Meridian Rd & Eastonville Rd
Falcon, CO 80831

MURPHY USA

SITE PLAN

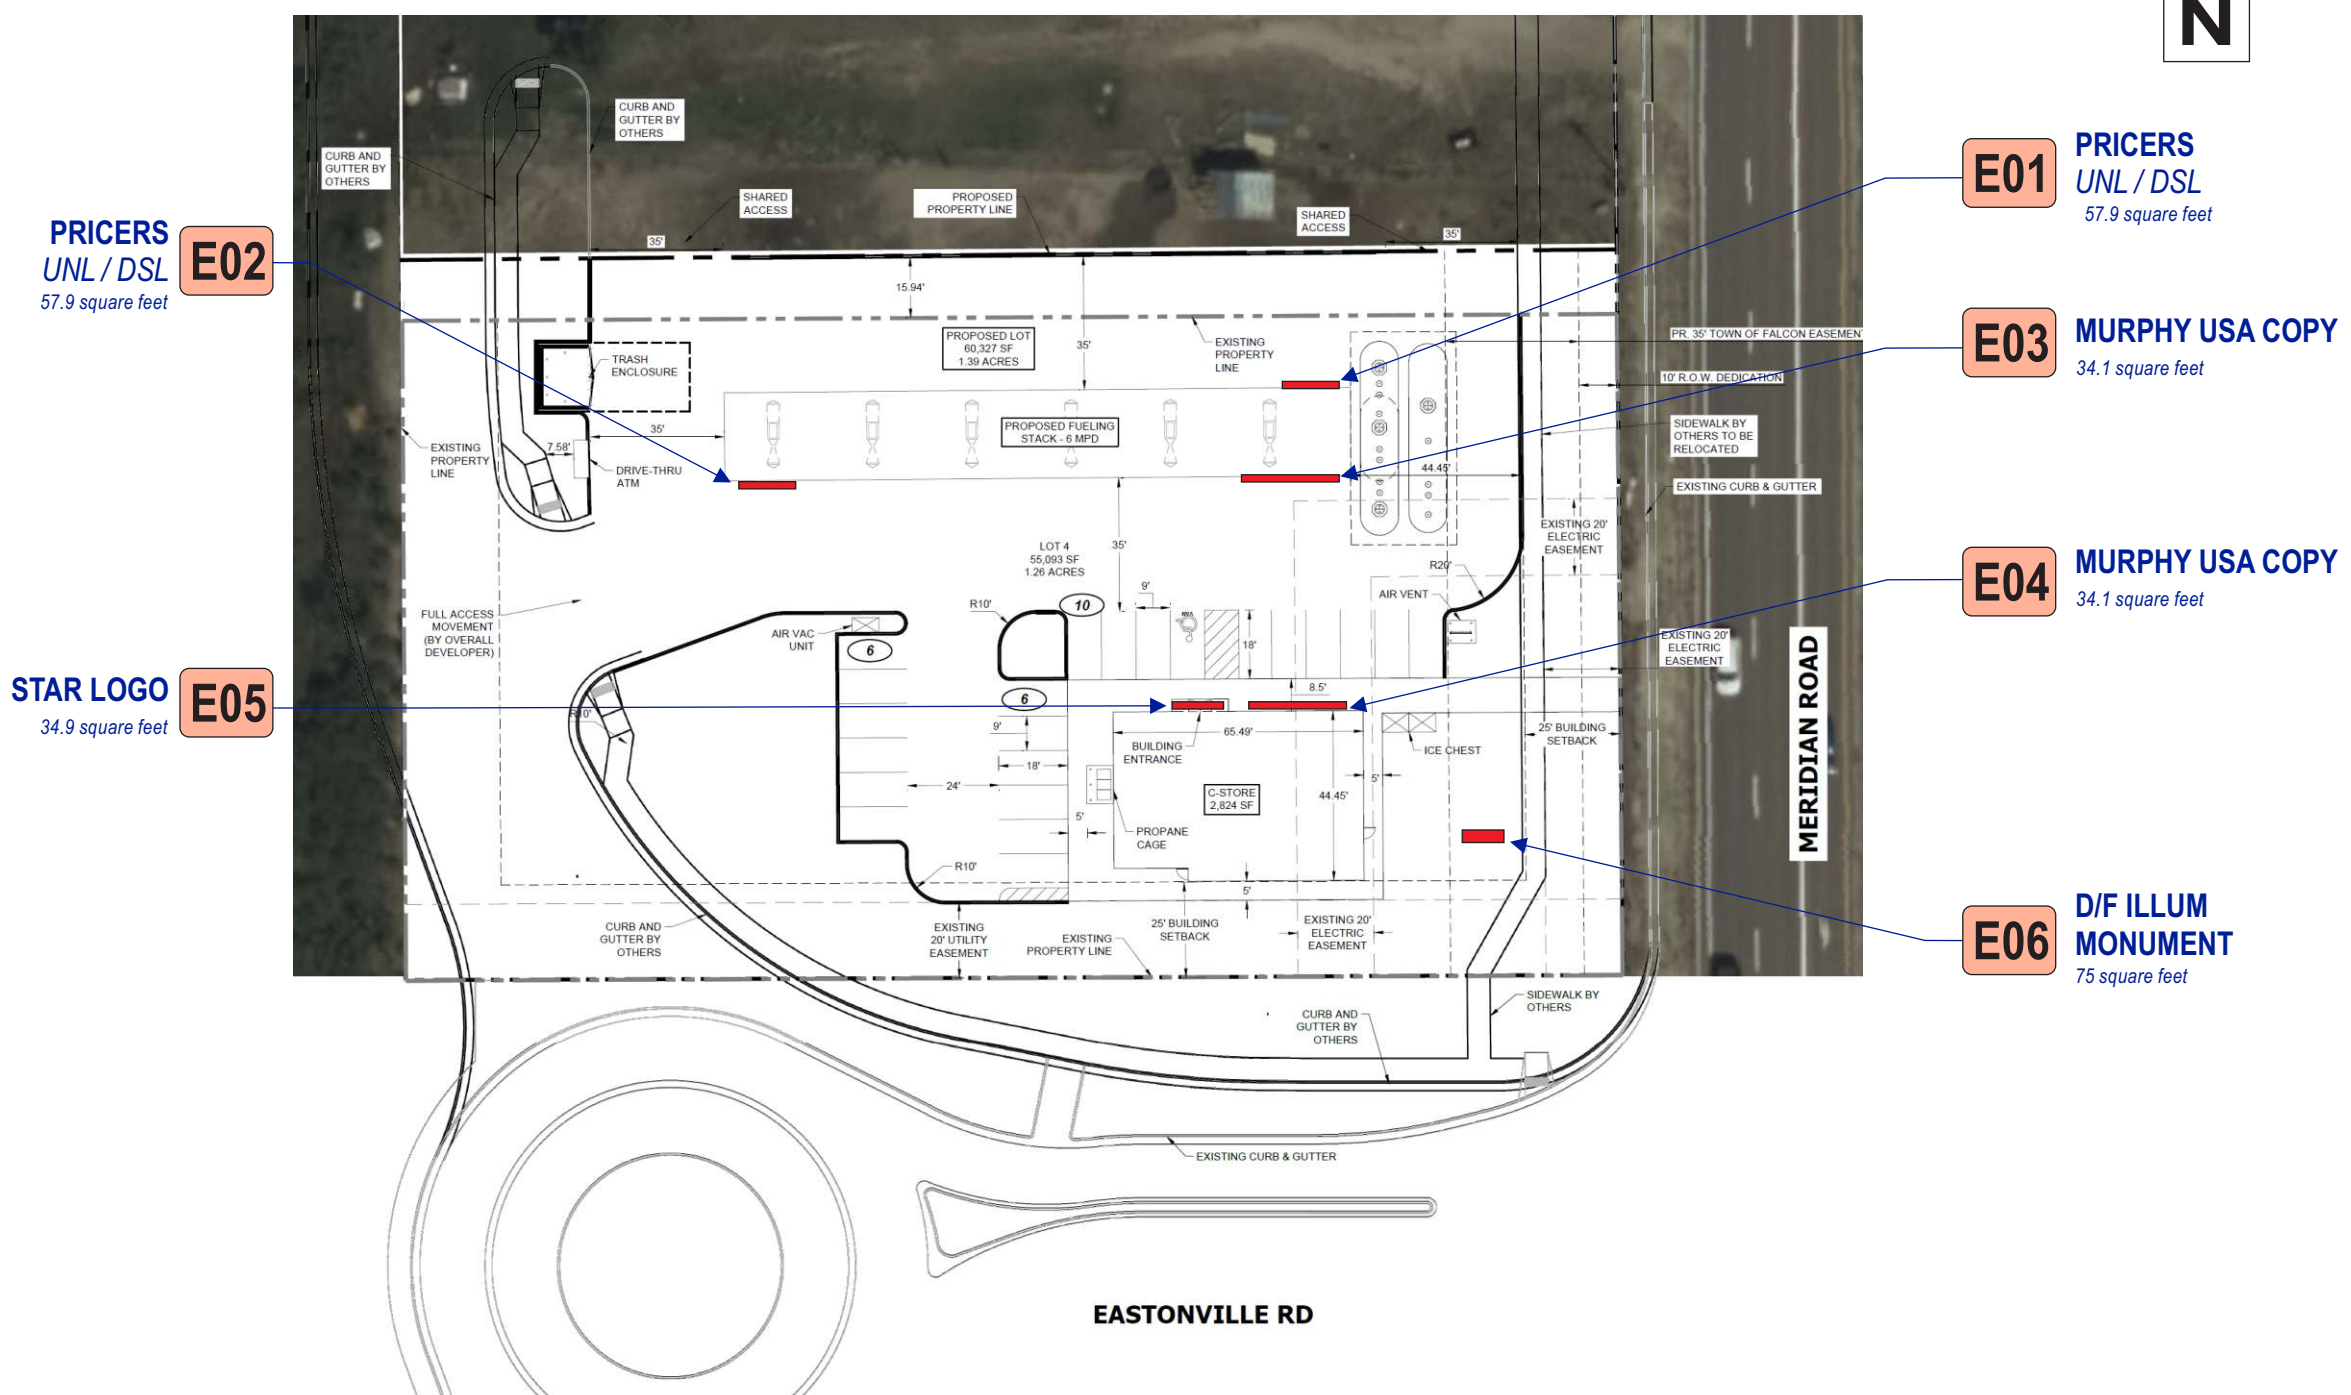
Per comments from
Enumerations:
Store address should
be 7825 Meridian
Park Drive , Gas
Canopy is 7829
Meridian Park Drive.

Please include:
- tax schedule number
- current zoning

VARIANCE DETAILS

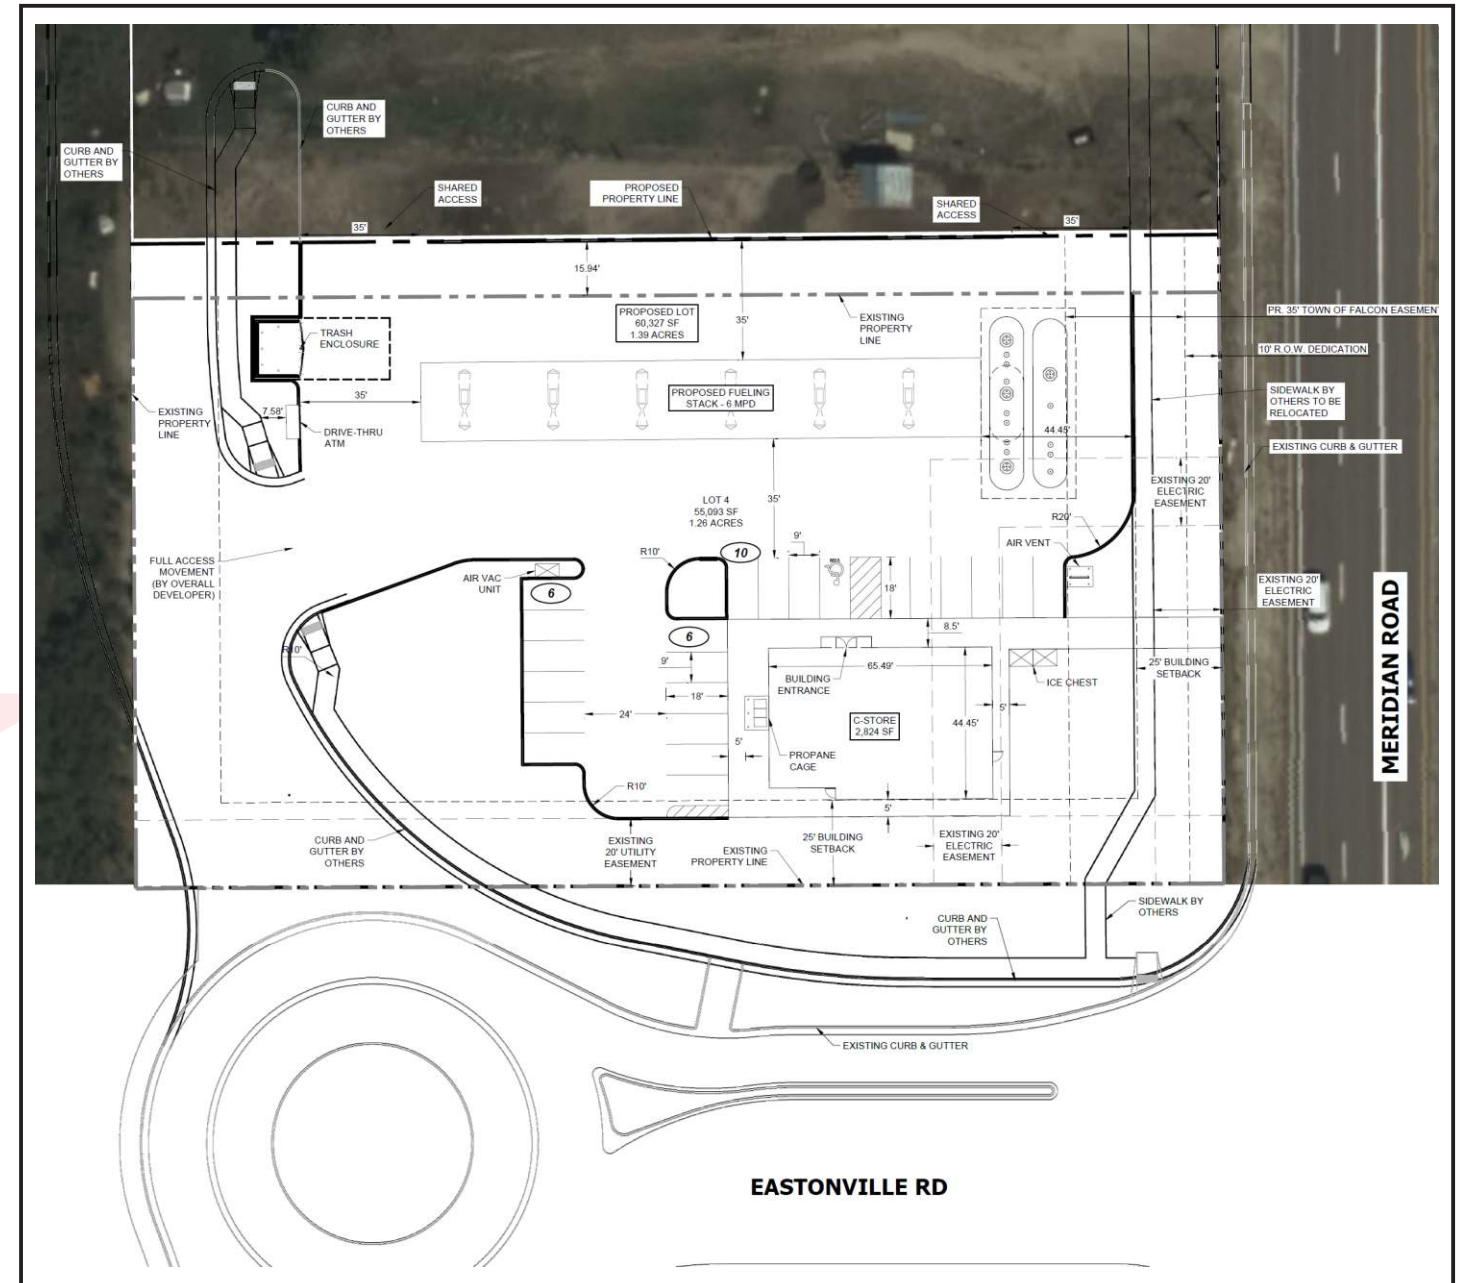
Please include location height and intensity of outdoor illumination for signs where applicable

OVERVIEW SITE PLAN

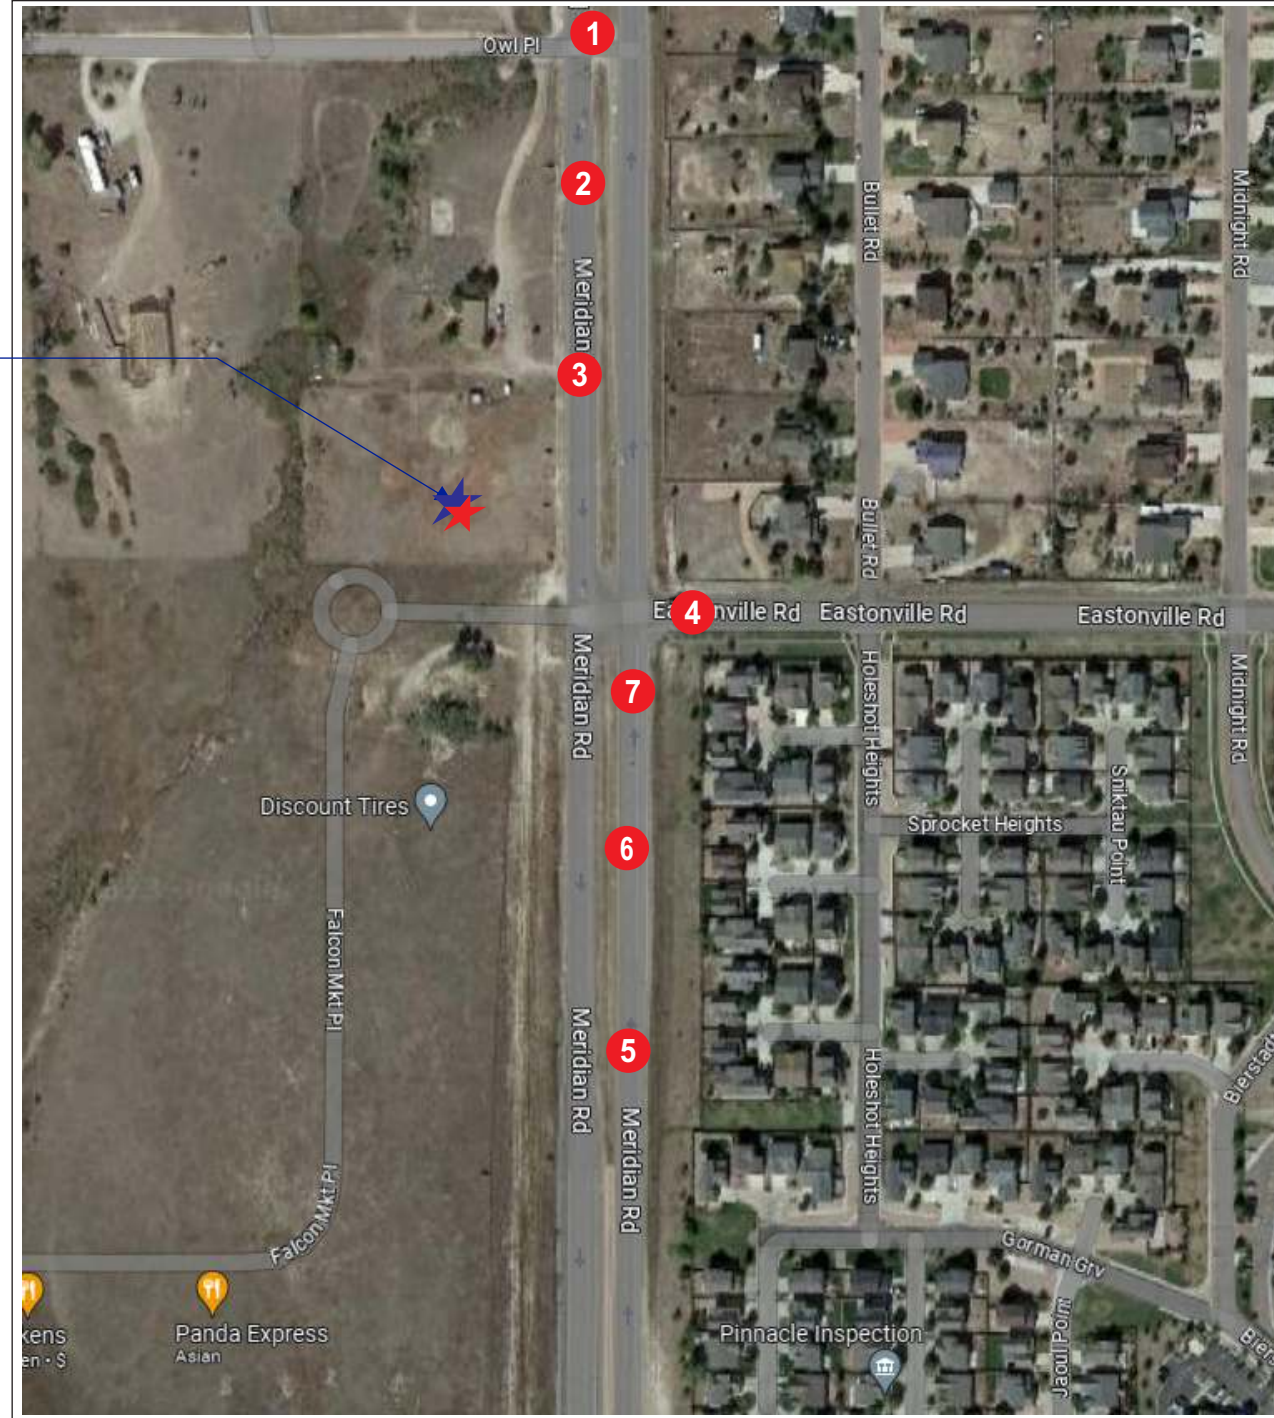
Please include a graphic scale

This area does not match up with the Site Development Plan
